Application by Green Hill Solar Farm Ltd. for an Order granting Development Consent for a proposed solar development on land between Northampton and Wellingborough

CPRE Northamptonshire
Feedback on Applicant's Responses to Written Representations
Deadline 4, 14th January 2026

This document contains CPRE Northamptonshire's reactions to the responses submitted by the Applicant in their document **REP3-73** that respond to our comments in Deadline 2 submissions from **REP2-068** and **REP-069**.

Figure 4.22 Indicative Permissive Paths

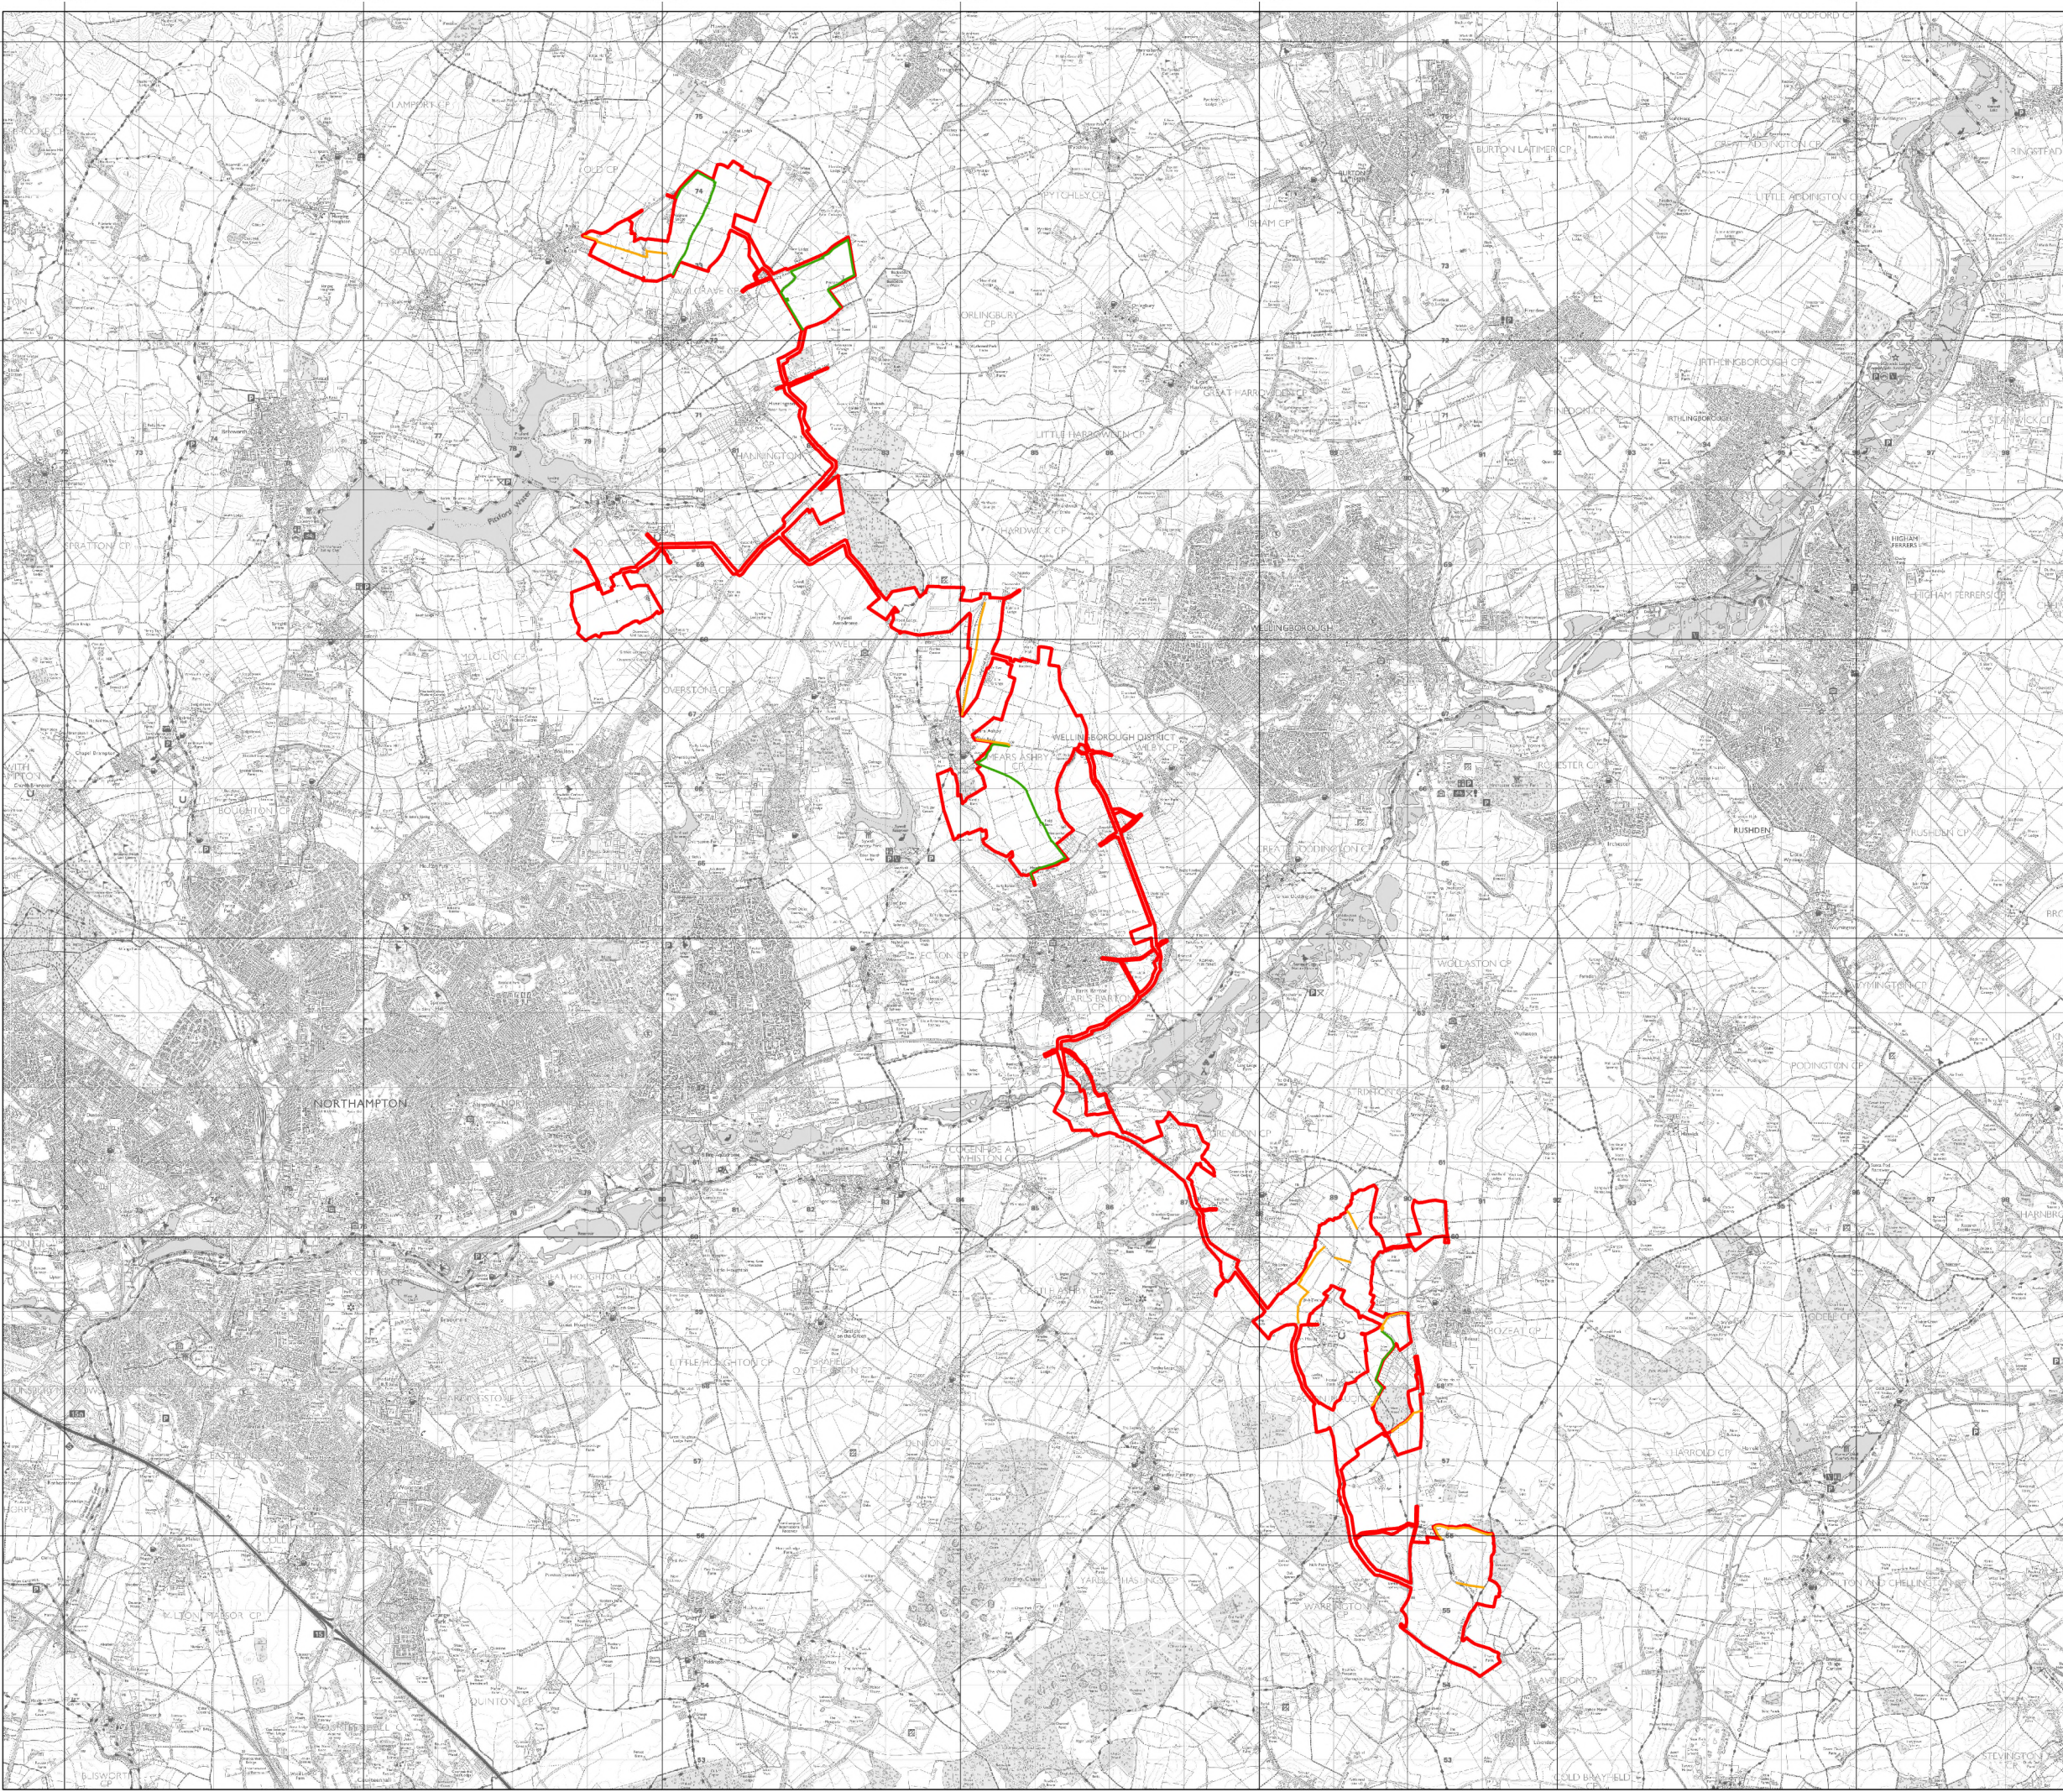
<p>will be updates in due course that address the substantive issues raised by CPRE.</p>		
CPRE-003	<p>We are pleased to note that the Local Impact Reports support our conclusions that:</p> <ul style="list-style-type: none">• there would be an adverse impact upon the landscape• there would be an adverse change to the landscape character• they judge that the landscape impacts would be greater than the applicant suggests• local roads need to be assessed for glint and glare not least because some are heavily used• the community benefit scheme should form a part of the DCO• a bond or other mechanism is required to secure decommissioning <p>However, we believe that WNC para 4.169 mistakenly suggests that the permissive paths could be a legacy because the Outline Decommissioning Statement states that they would be removed.</p>	<p>The Applicant notes this comment and refers to the Applicant's Responses to Local Impact Reports [REP2-049]. The Applicant refers to WNC 4.170 to 4.175 in the Applicant's Responses to Local Impact Reports [REP2-049] regarding the permissive path and the Applicant has prepared an update to the Public Rights of Way Plan Revision C [EX3/GH2.6_C] as we have now been provided with the definitive map data layer.</p>	<p>Noted.</p> <p>This response and the response in REP2-049 do not acknowledge that the permissive paths will be removed and so must not be considered a legacy.</p>
